Planning Application Reference No.: 3/2022/1072

Address of Development: Pewter House Farm, Carr Lane, Balderstone, Blackburn BB27 LN

RE: APPLICATION 3/2022/1072 : PEWTER HOUSE FARM CARR LANE BALDERSTONE

CLIENT DETAILS		DRAWING No		REVISION	
MAIN STREET BINGLEY BRADFORD		RBV-PL-004			
DRAWING INFO		SCALE	DATE	DRAWN BY	
Elevations as Proposed		1:100/200	05/09/22	JH

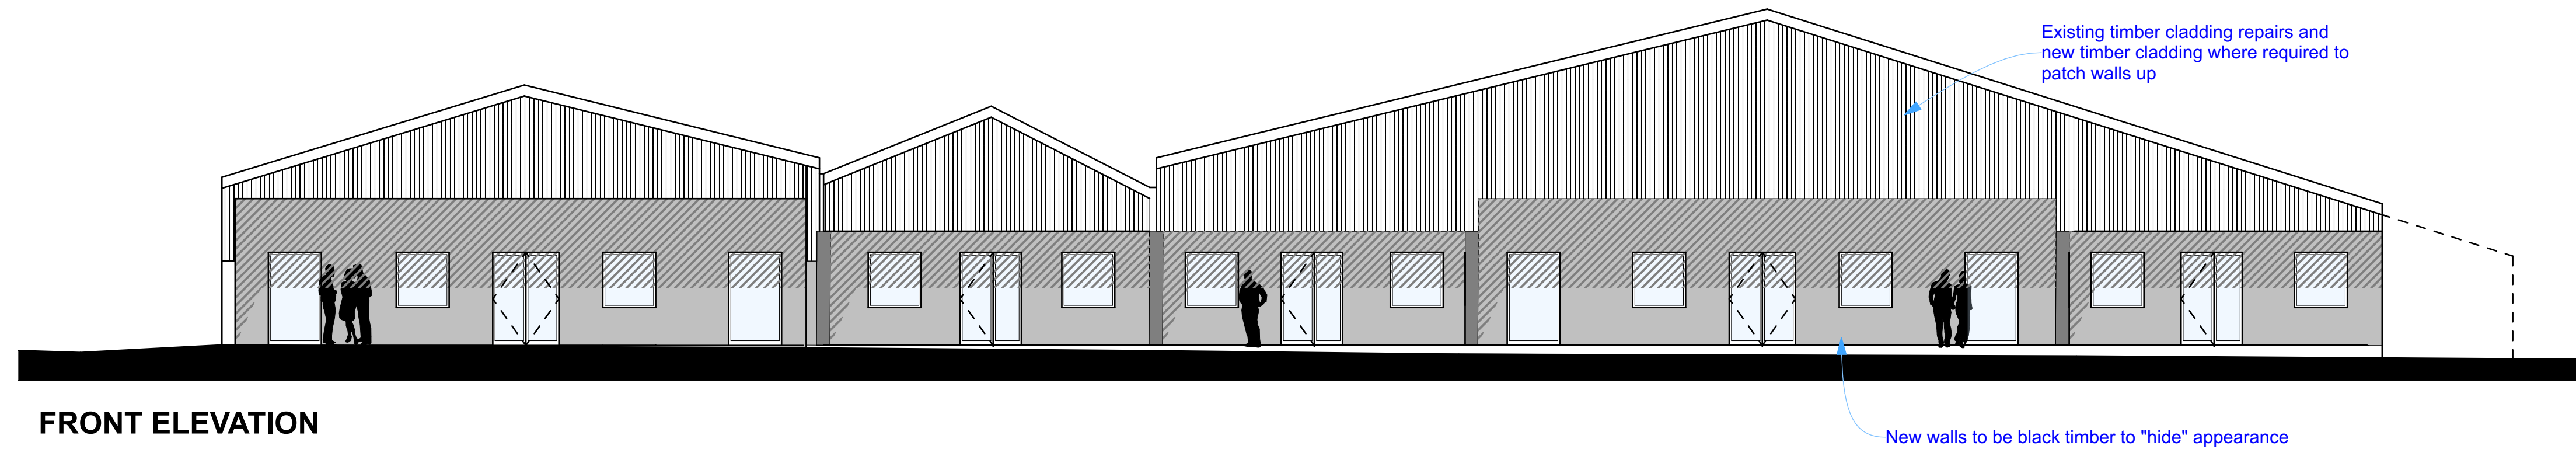
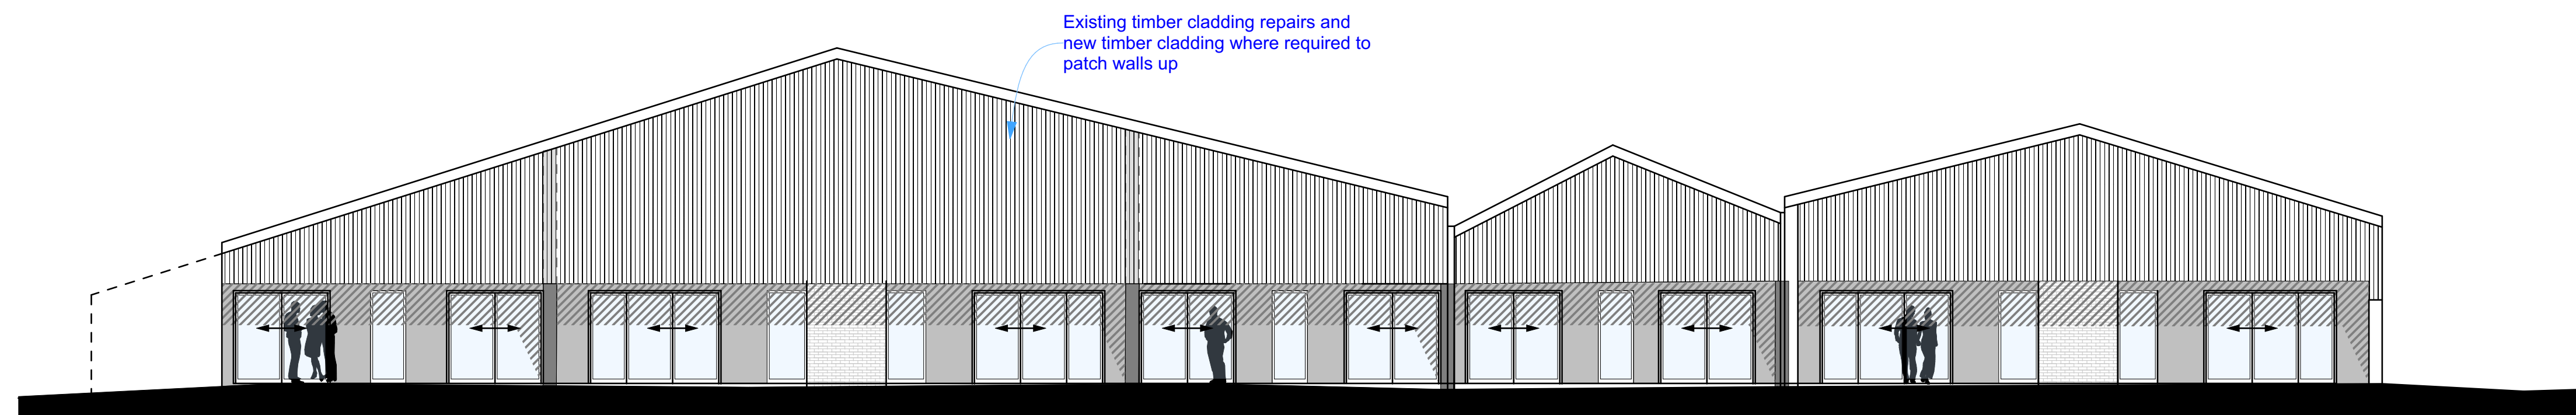
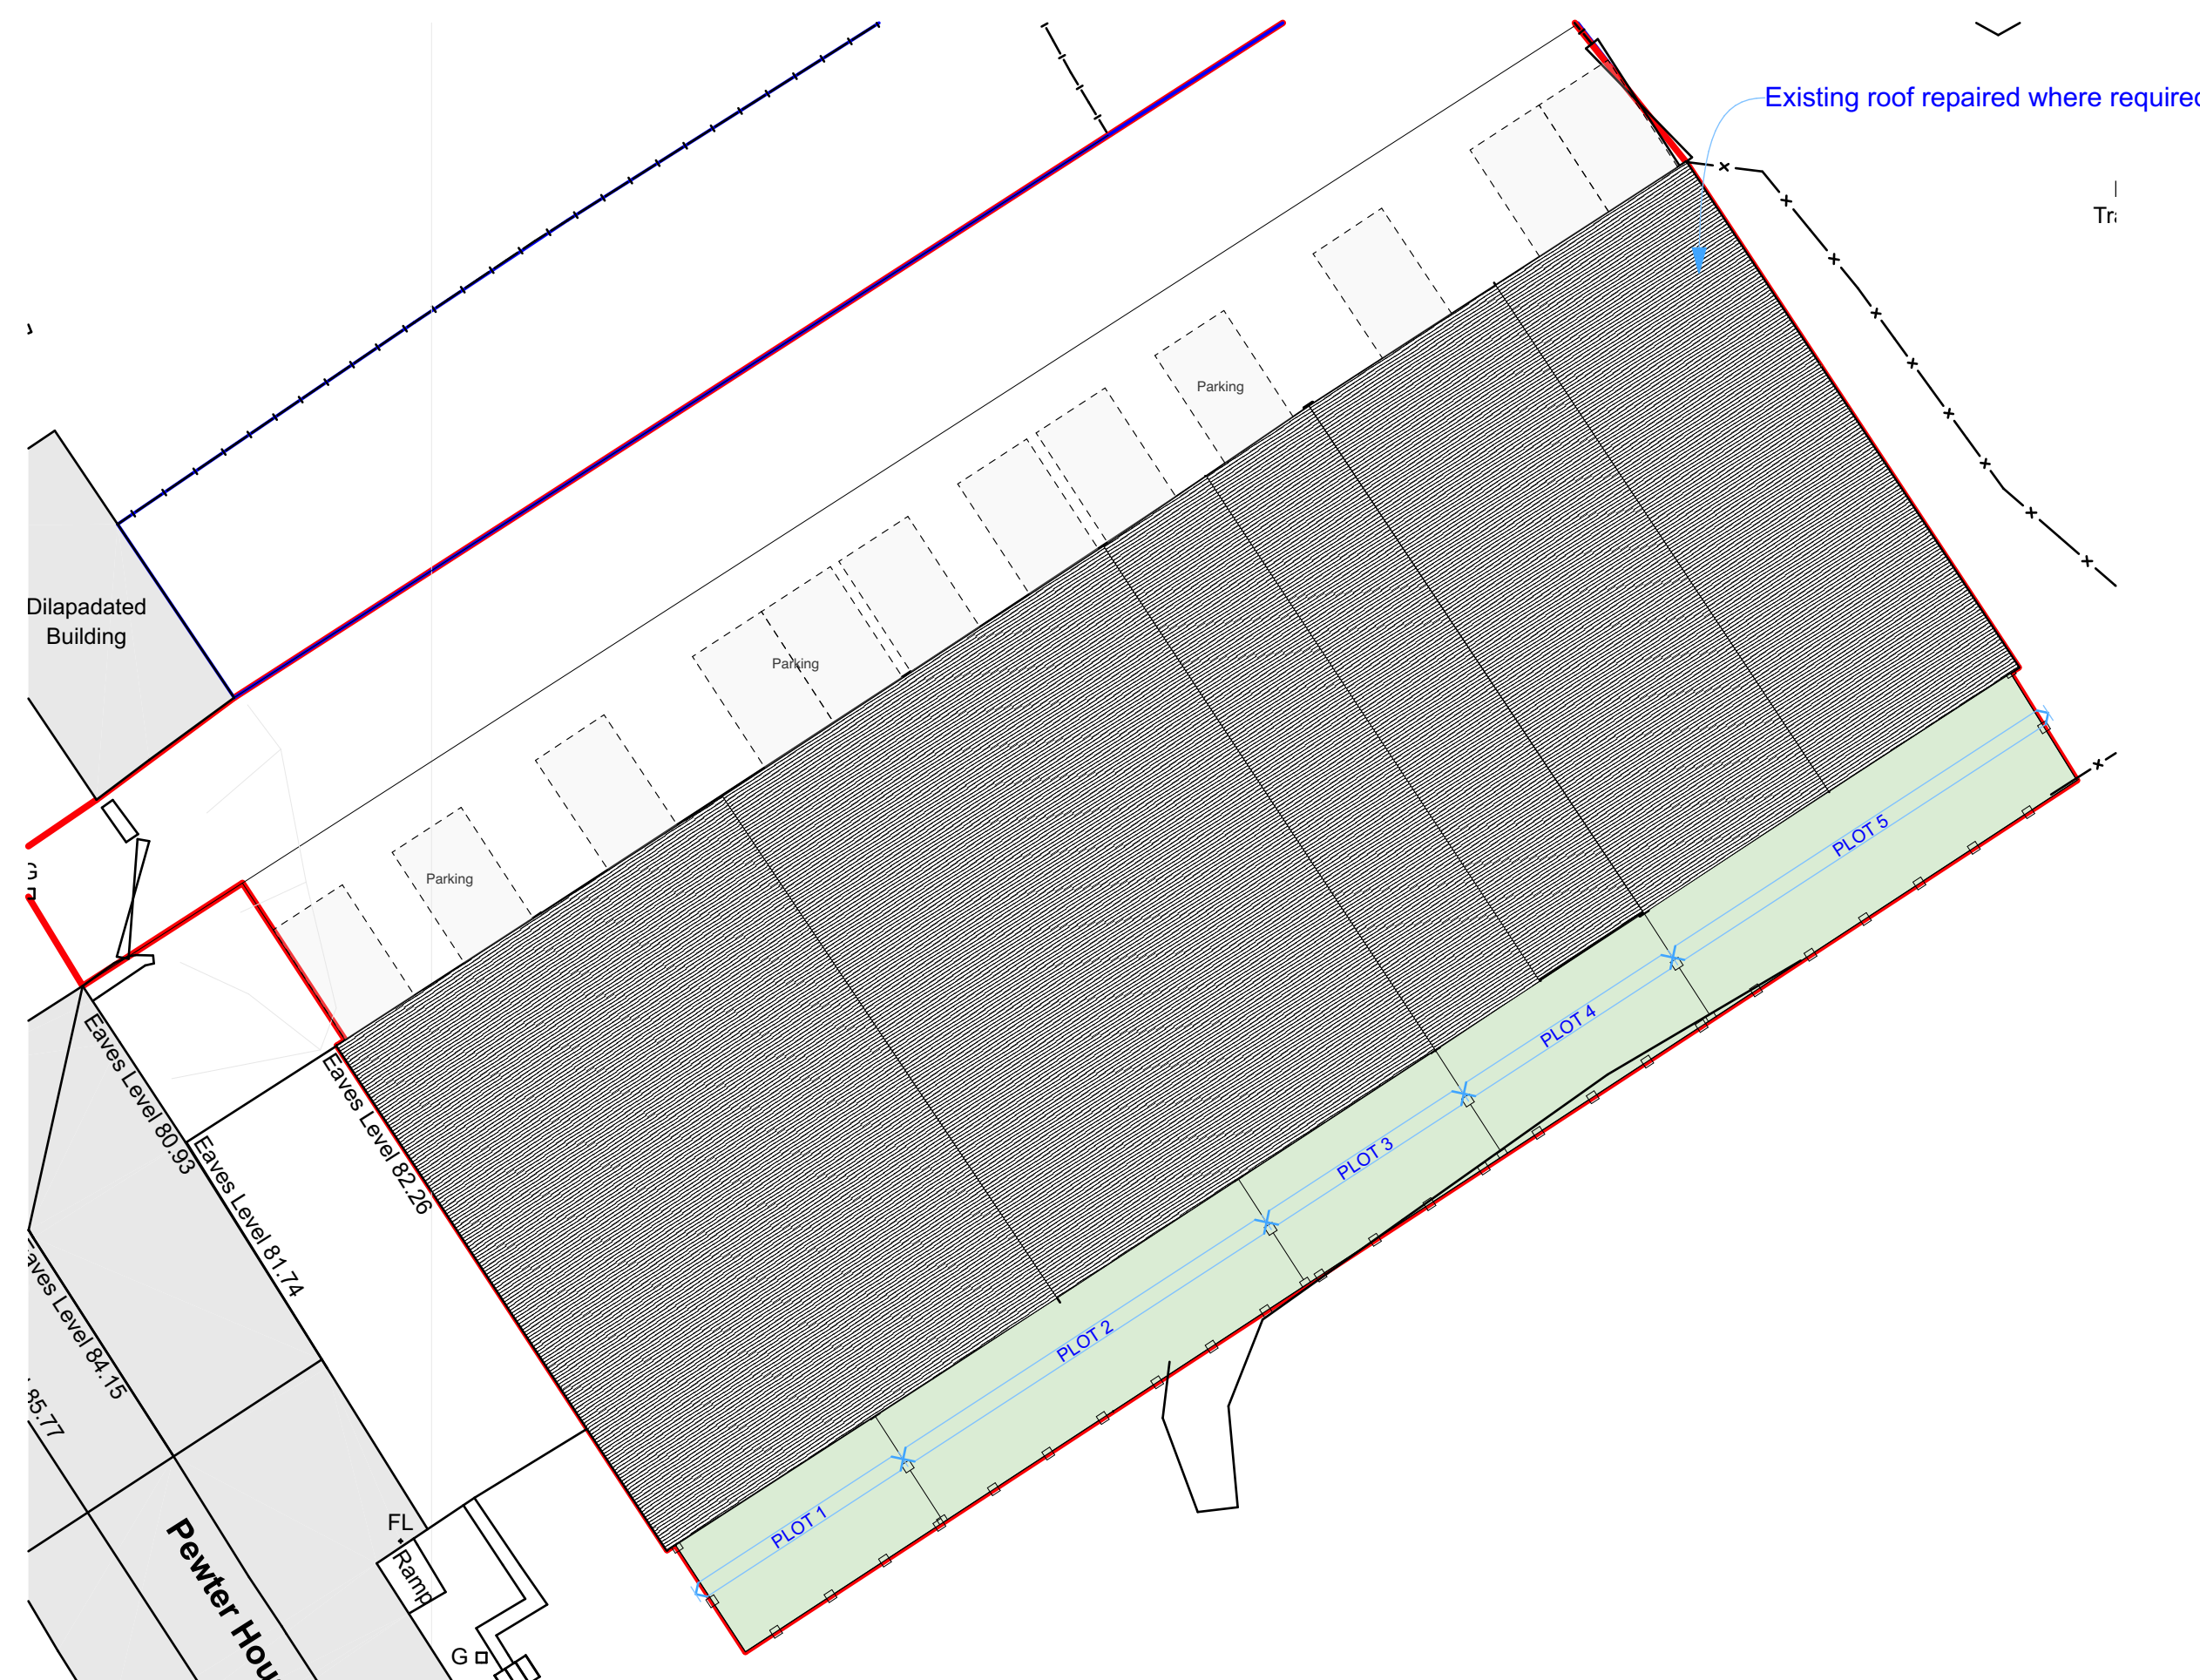
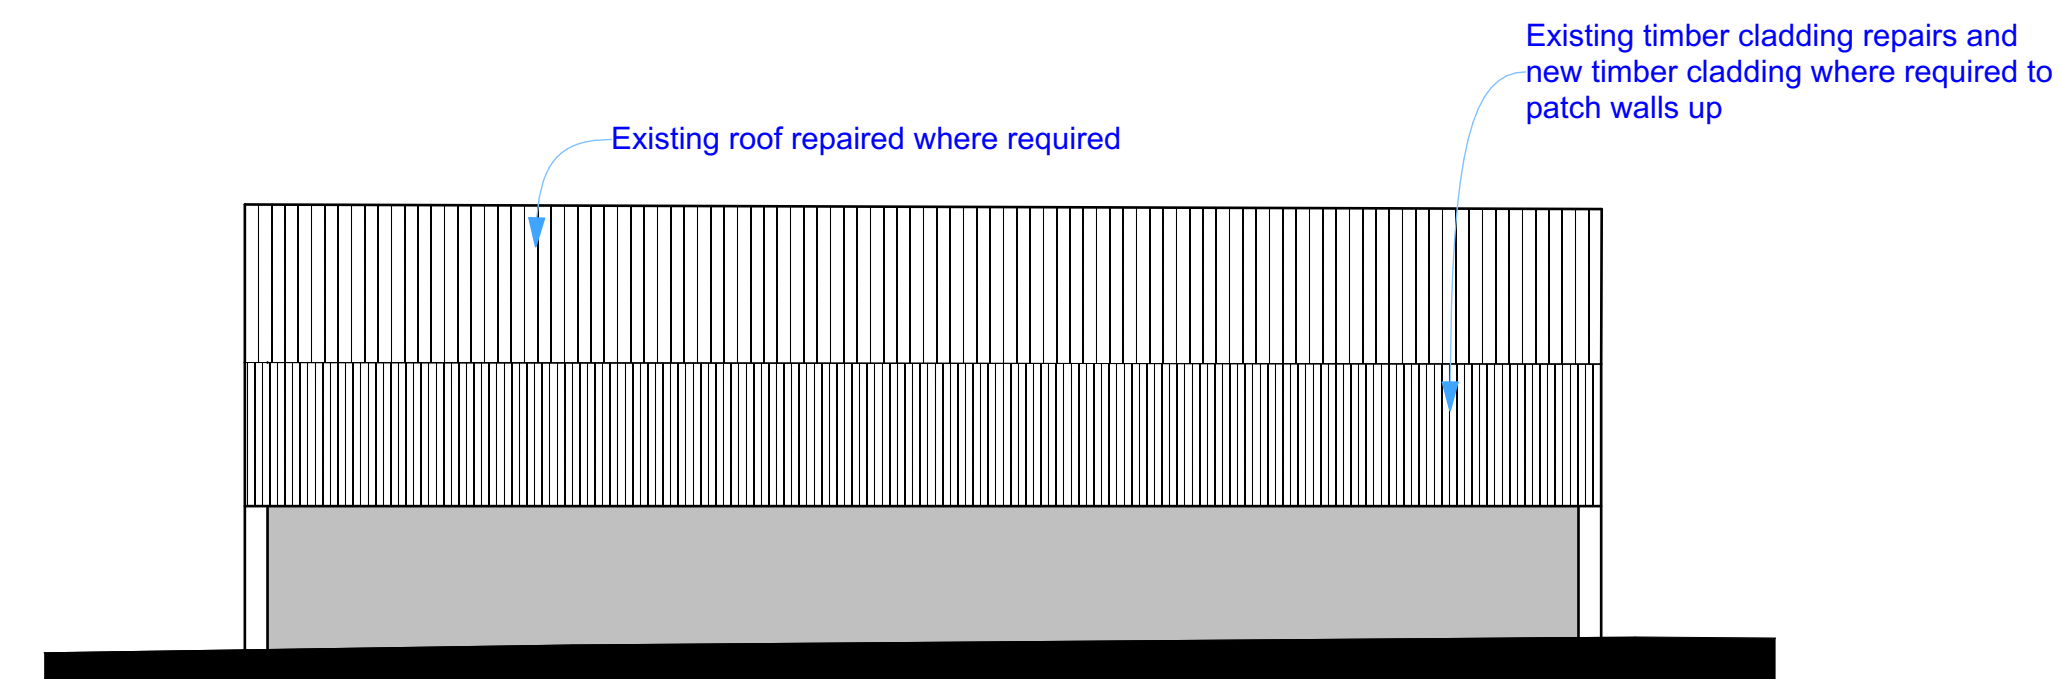
1. The building operations proposed as part of the development would go beyond what is "reasonably necessary" to change the use of the buildings and would include the construction of new structural elements for the buildings contrary to Class Q, Q.1 (i) of Schedule 2 Part 3 of the Town and Country Planning (General Permitted Development) (England) Order 2015.

The Applicant has provided no evidence of any change to the proposed building operations apart from some notes on the proposed elevations which state that there will only be a need for some "repairs where required". We would submit that the Council has already reached a decision that the work required goes beyond what is "reasonably necessary" on the basis of previous proposals and supporting documentation provided by the Applicant. The Applicant has not changed anything about that aspect of the proposals.
